Consultation Response from Mike Hibbert,  
KC Waste Strategy( Refuse & Recycling)

2023/92966 Land to the rear of, 271, Cliffe Lane, Gomersal, Cleckheaton, BD19 4SB

Demolition of existing dwelling and erection of 97 dwellings including formation of a new access from Cliffe Lane, landscaping, public open space and all associated infrastructure and engineering works

Date Responded: 03/12/2024.

Drawing Number	152130-001	Rev	A
----------------	------------	-----	---

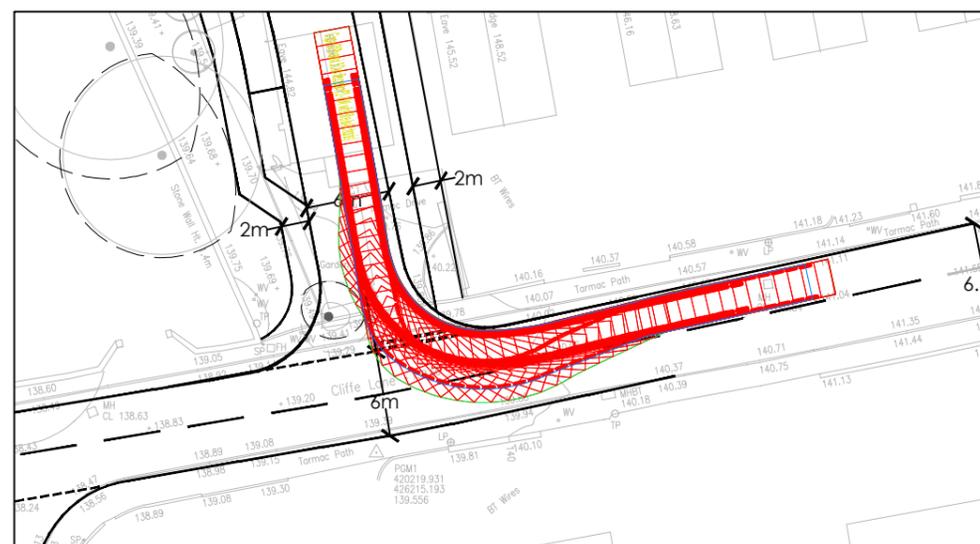
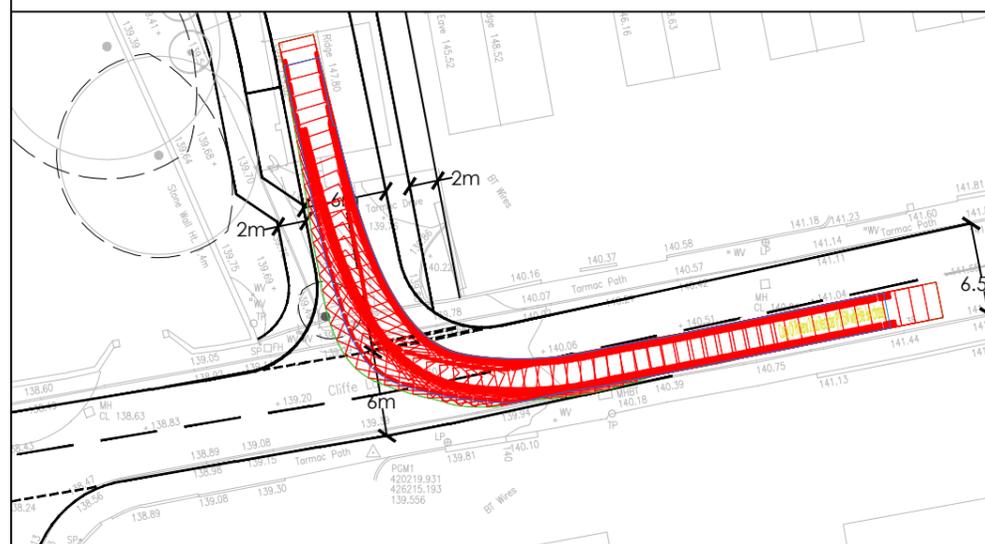
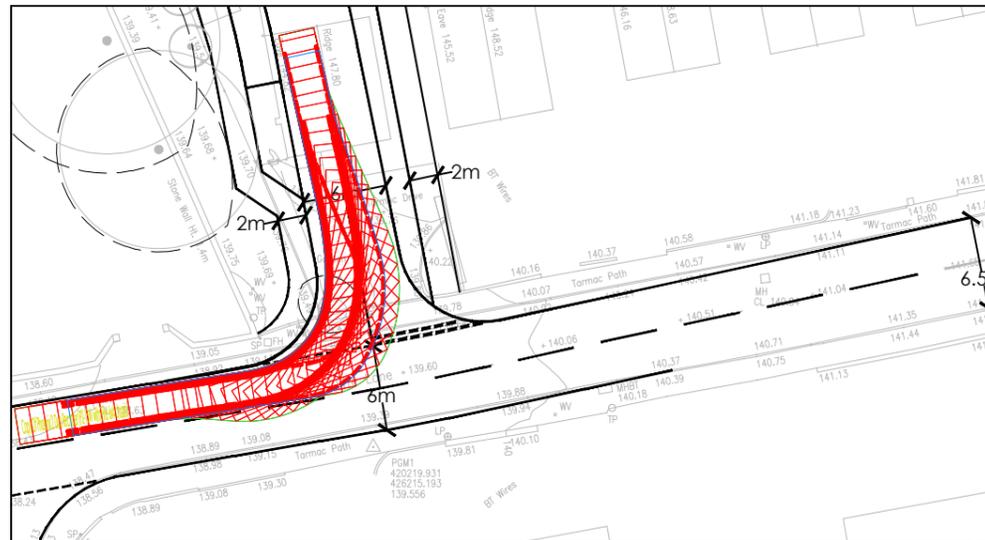
The applicant has submitted Swept Path Analysis Dwg N0. 152130-002 Rev B dated 20/09/2024.

It is noted that the RCV dimensions used for the analysis are an RCV length of 11.85m where the largest RCV in the current collection fleet is 11.22m in length.
